Re: Rough-In Reinspection — 250 Koerner Lane, Erwin, NC

Permit #: SFD2503-0086

Project: 250 Koerner Lane – Rough-In Inspection Response

item 16 Header adjusted,
85" clearance achieved.

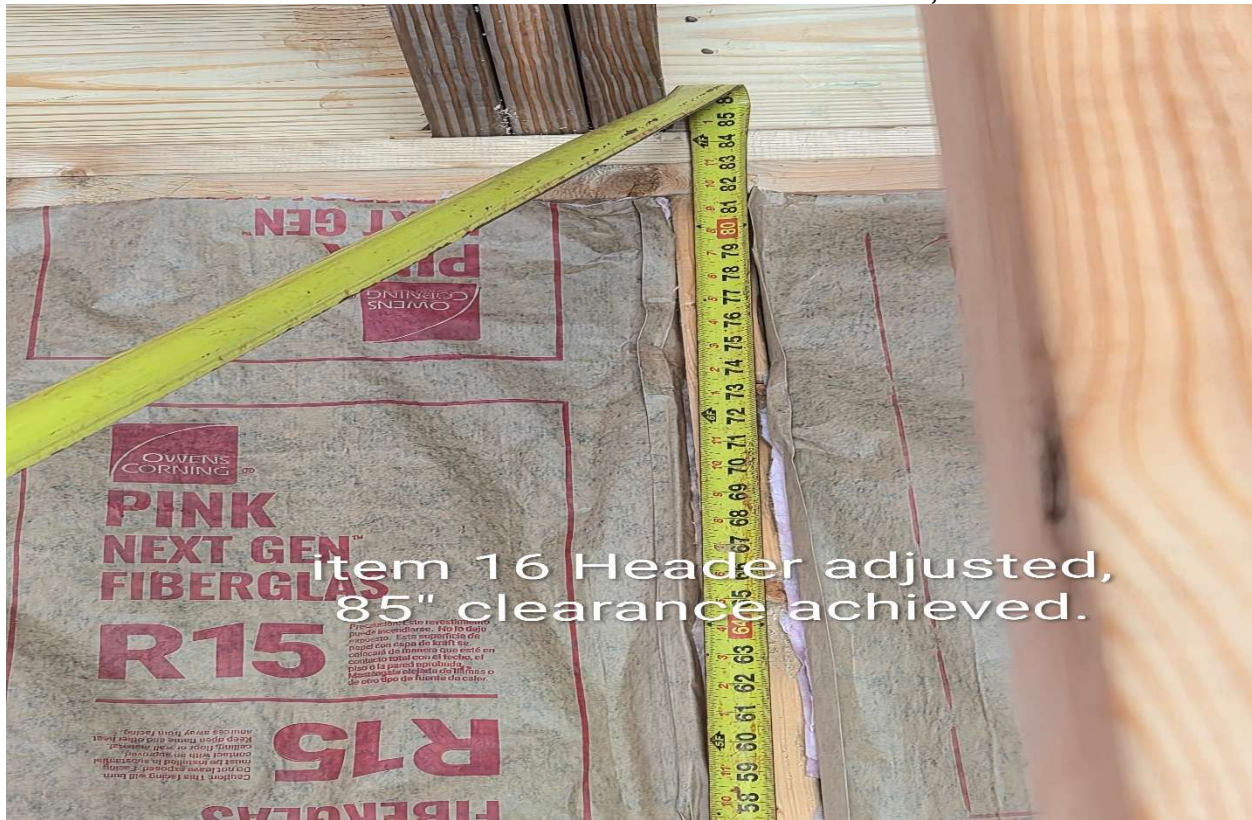
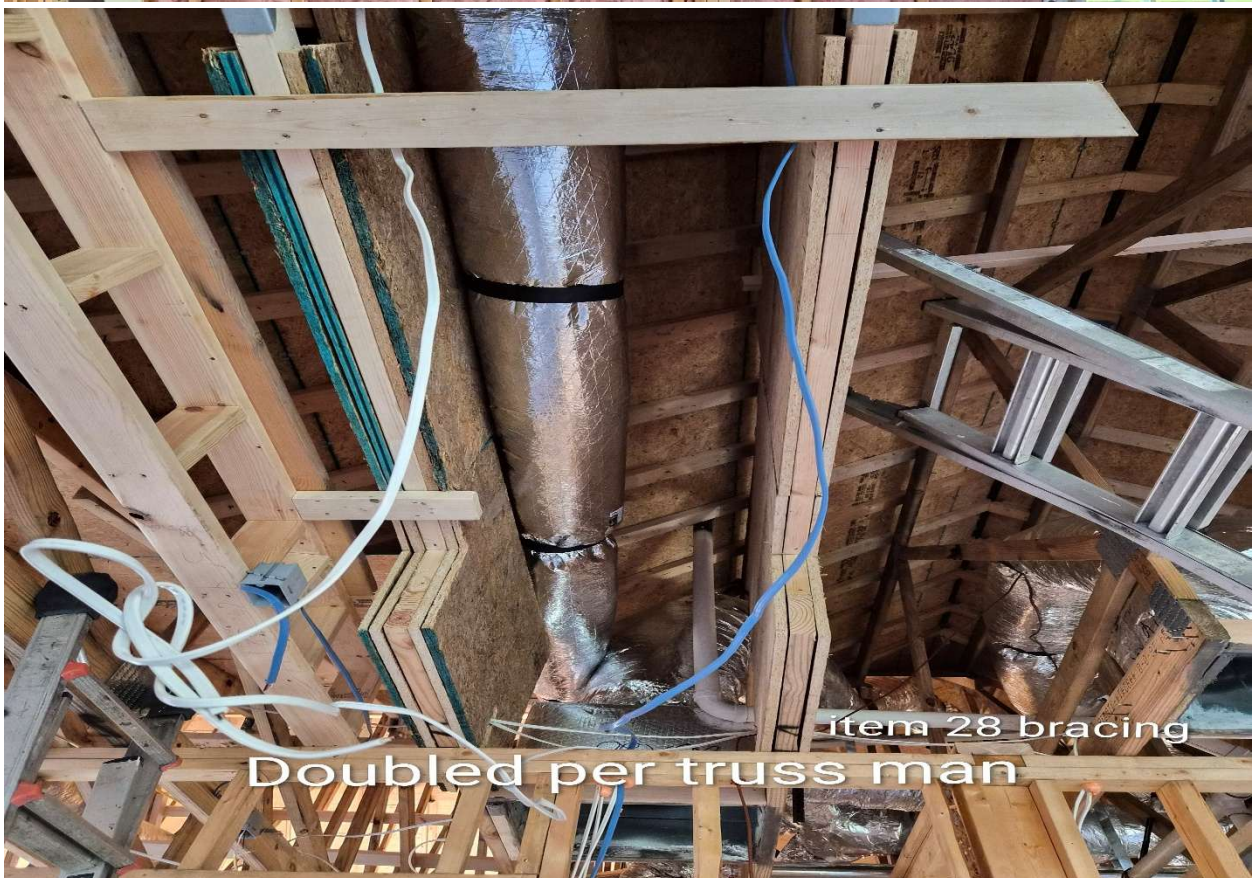
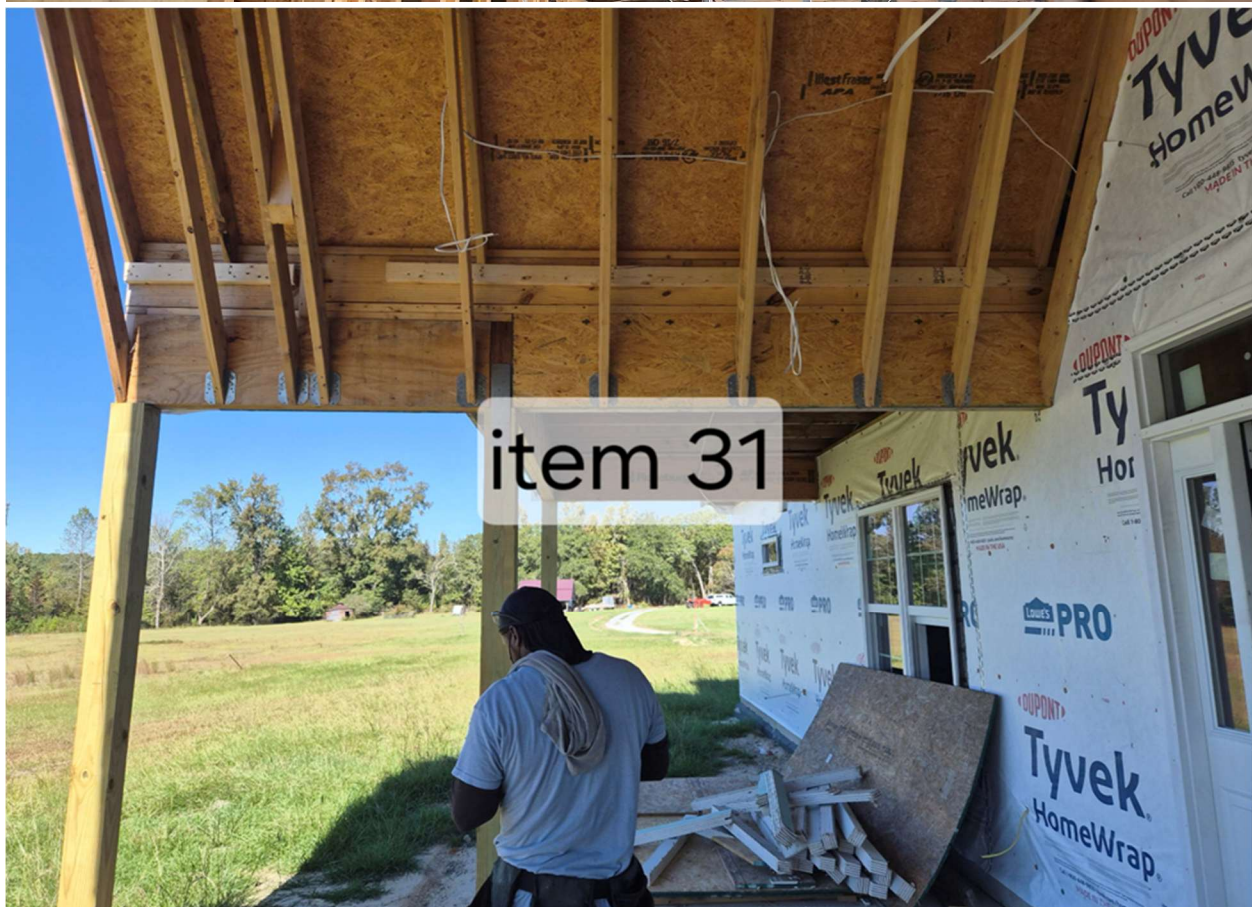
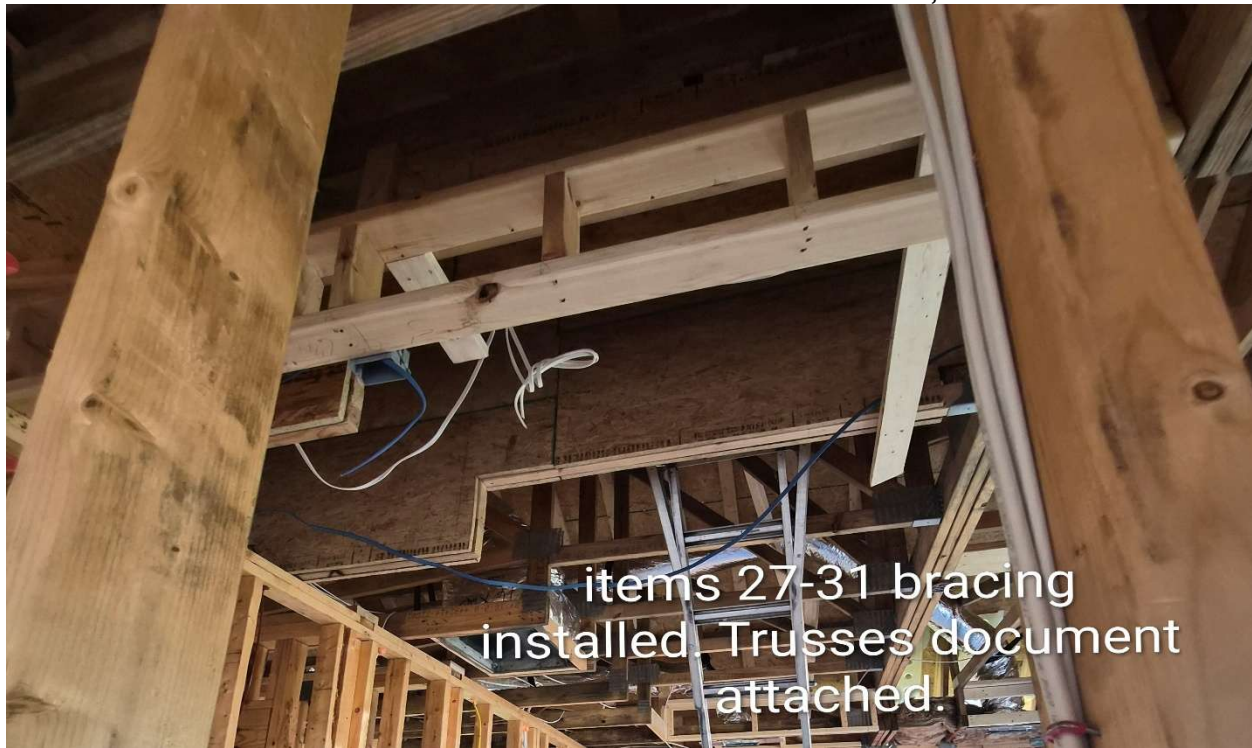
15	Need to fasten all 2-ply and 3-ply girder trusses per doc	All multi-ply trusses fastened per engineered spec.	Item15_GirderTrussFastened.jpg
16	Stairs headroom height below 80 inches	Header adjusted to achieve 80" clearance.	Item16_StairHeadroom.jpg
17	Main house door from breezeway – anchor bolts both sides ran out of space	Installed ramset concrete fastener.	Item17_MainDoorAnchor.jpg
18	Fasten all electrical lines moved throughout house	Secured all relocated wiring with approved staples/clamps.	Item18_ElectricalSecured.jpg
19	Seal holes to exterior (master bedroom & closet area)	Sealed all penetrations with foam and caulk.	Item19_MasterSeal.jpg
20	Fire stop front left room at top plate	Installed fire-blocking material.	Item20_FireStop_FrontLeftRoom.jpg
21	Hanger for attic access	No code reference. Not required.	Item21_AtticAccessHanger.jpg
22	Strap four-stud column (front door, left closet)	Installed approved metal strapping.	Item22_FrontDoorColumnStrap.jpg

item 19 master closet
holes sealed

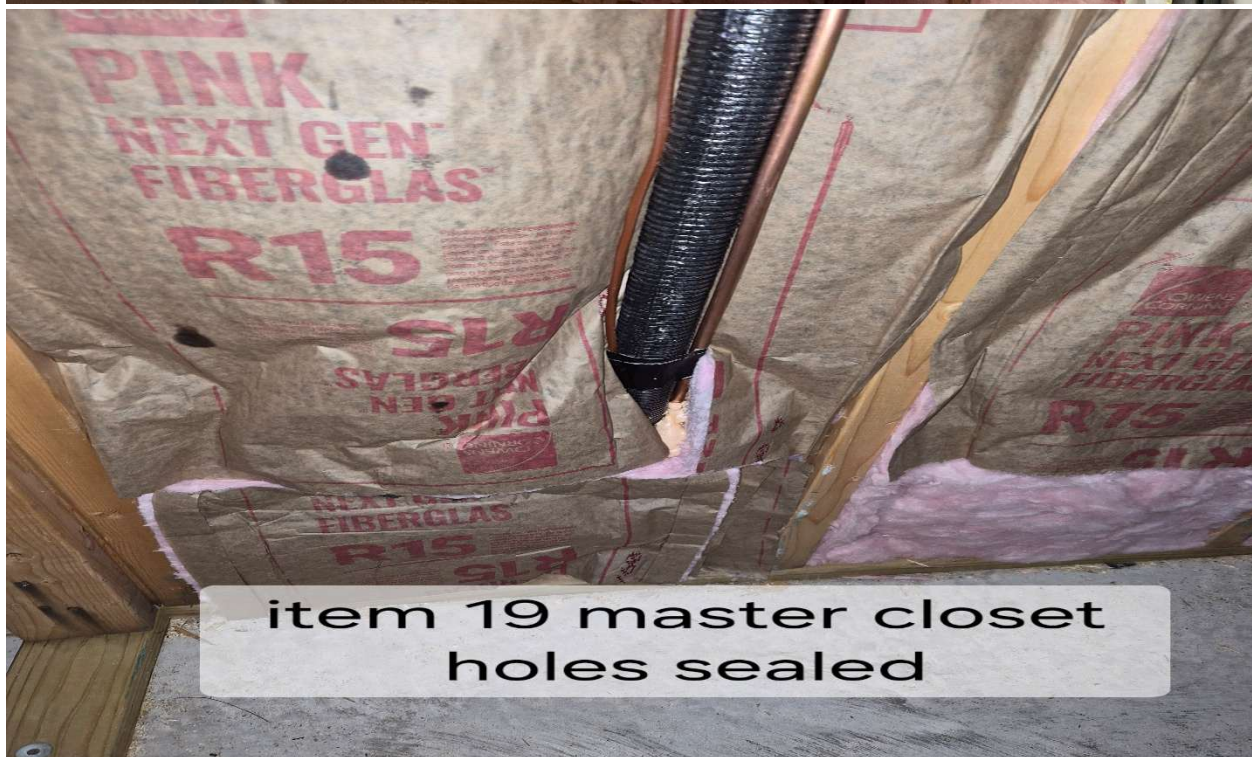
10/10/2025 1:36:03 PM List 2 18. Need to fasten all
electrical lines that have been moved throughout the
house 19. Need to seal holes to the outside master
bedroom and closet area 20. Need to fire stop front
left room at top plate 21. Need to hanger attic access
22. Need to strap four stud column front door left
closet 23. Missing anchor bolt right side, of front door
24. Need to fire stop Chase at right shower 25. Front
porch beam in front right bedroom bearing on osb
board. OSB board is non-structural. 26. Need to
remove insulation in right rear closet 27. Ao4 missing
hanger 28. a03,A04 I, A07,A09, AO 19 , aB01,
c013,Co6-C011missing bracing 29. A09,A10 these
repair letter in master bedroom 30. need to fasten all
three ply and 2ply girder trusses per plans 31. Front
porch stick belt rafters need to bear solid
